From: Gregg, Robert <Robert.Gregg@lancashire.gov.uk>
Sent: 19 December 2018 12:27
To: Rebecca Bowers
Cc: planning; LHS Customer Service
Subject: APP. 3/2018/1102 - 10 ST PETERS CLOSE, CLAYTON LE DALE

Proposed erection of a single storey rear extension and a two storey side extension

**PROPOSED SITE PLAN**  
Scale 1:100

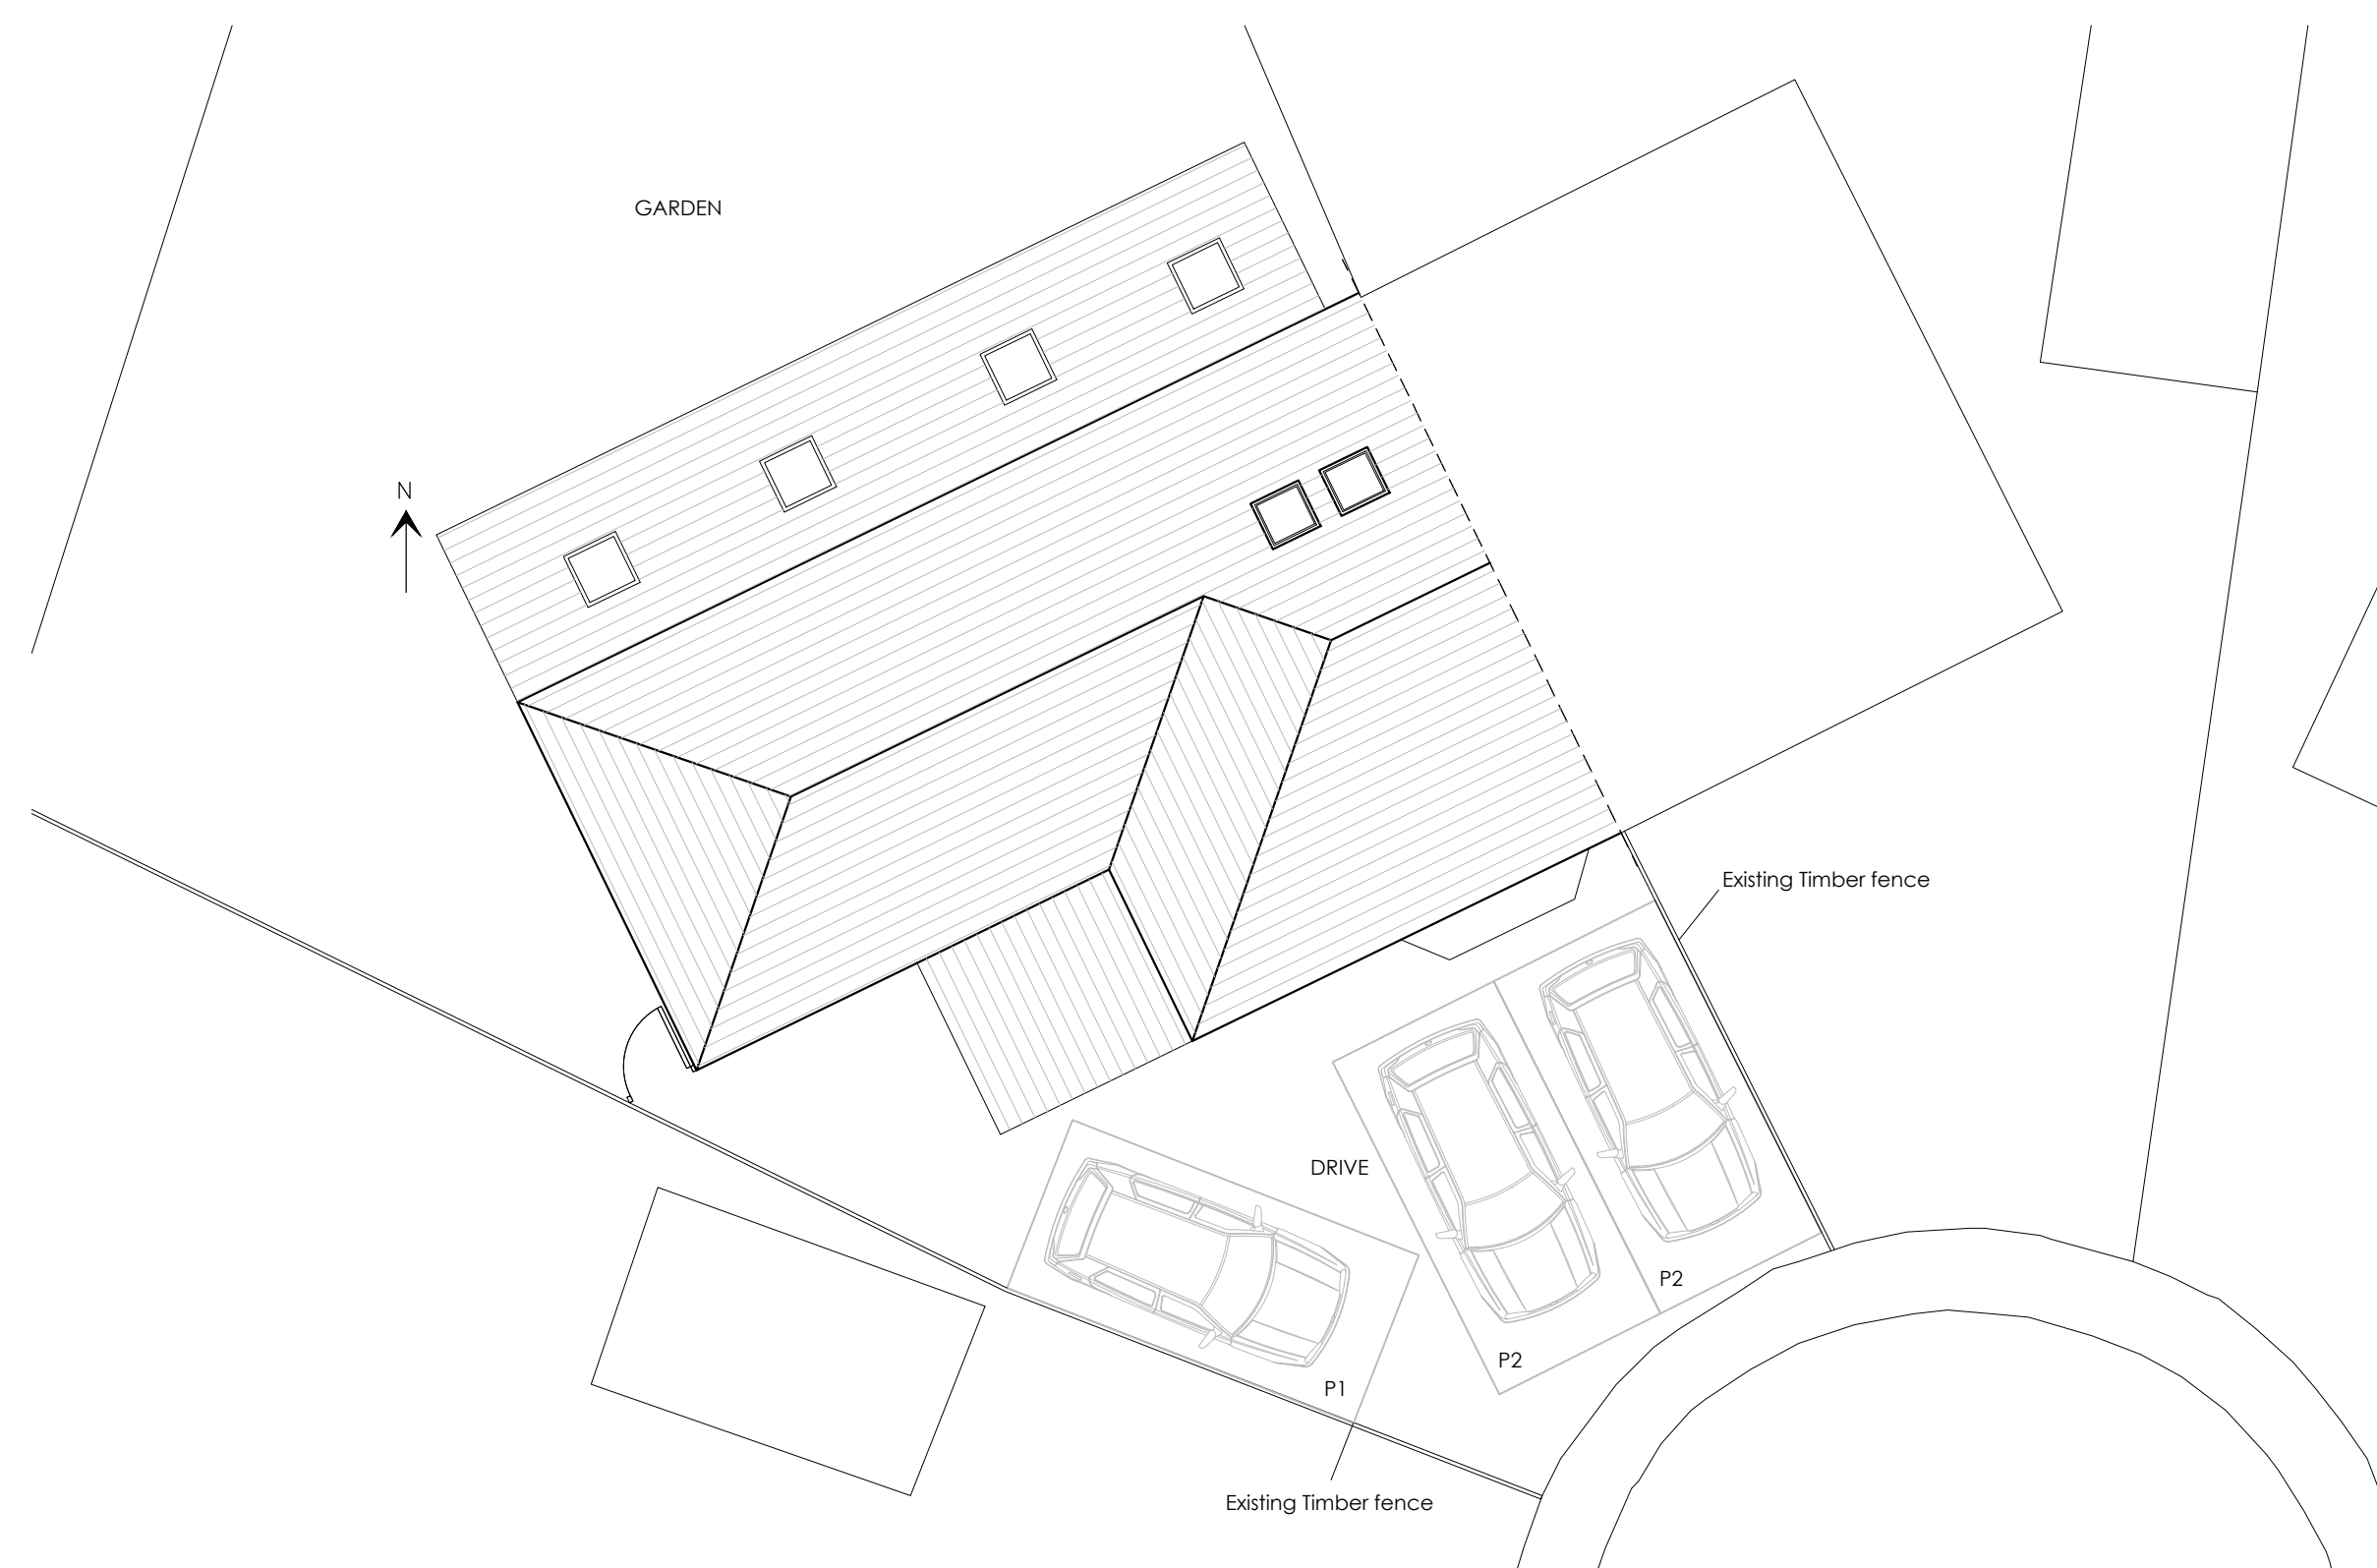
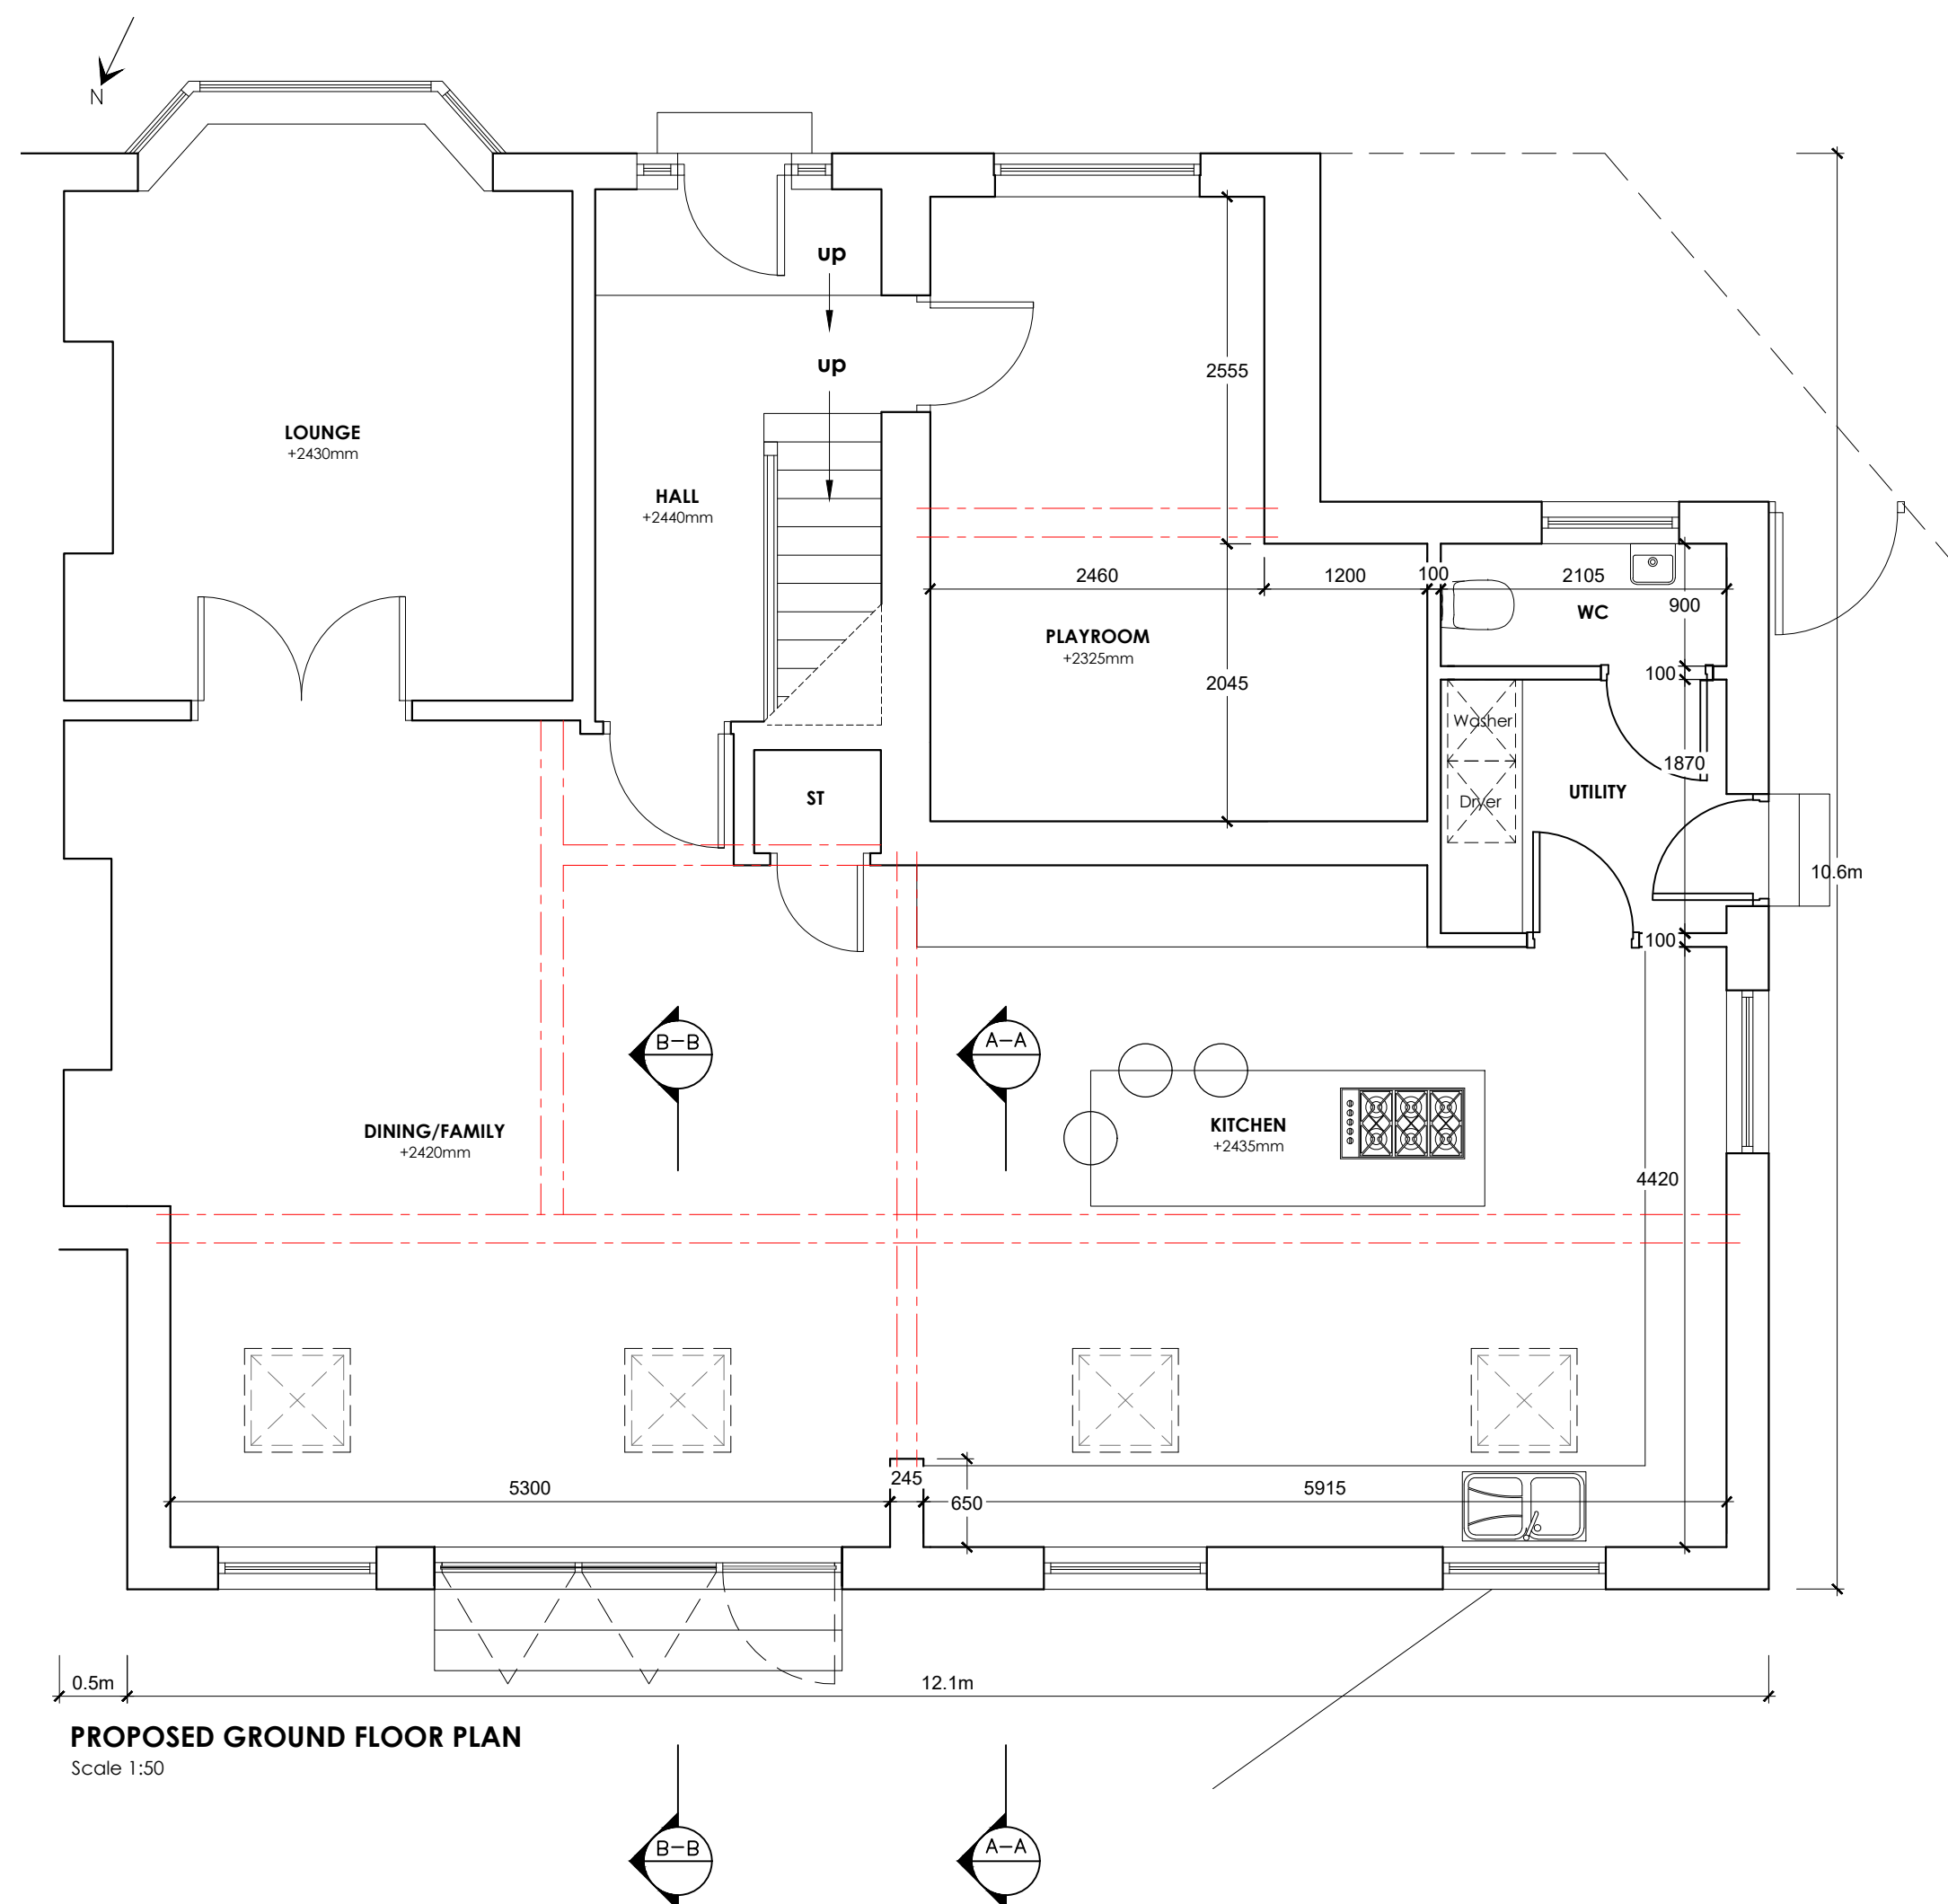
The proposed works would see the existing garage becoming a playroom which in turn would result in the loss of a parking space. However, the submitted plans indicate that such a loss will be accommodated within the curtilage of the dwelling to provide sufficient off-street parking for 3 vehicles.

I would therefore raise no objection towards the proposal on highway grounds.
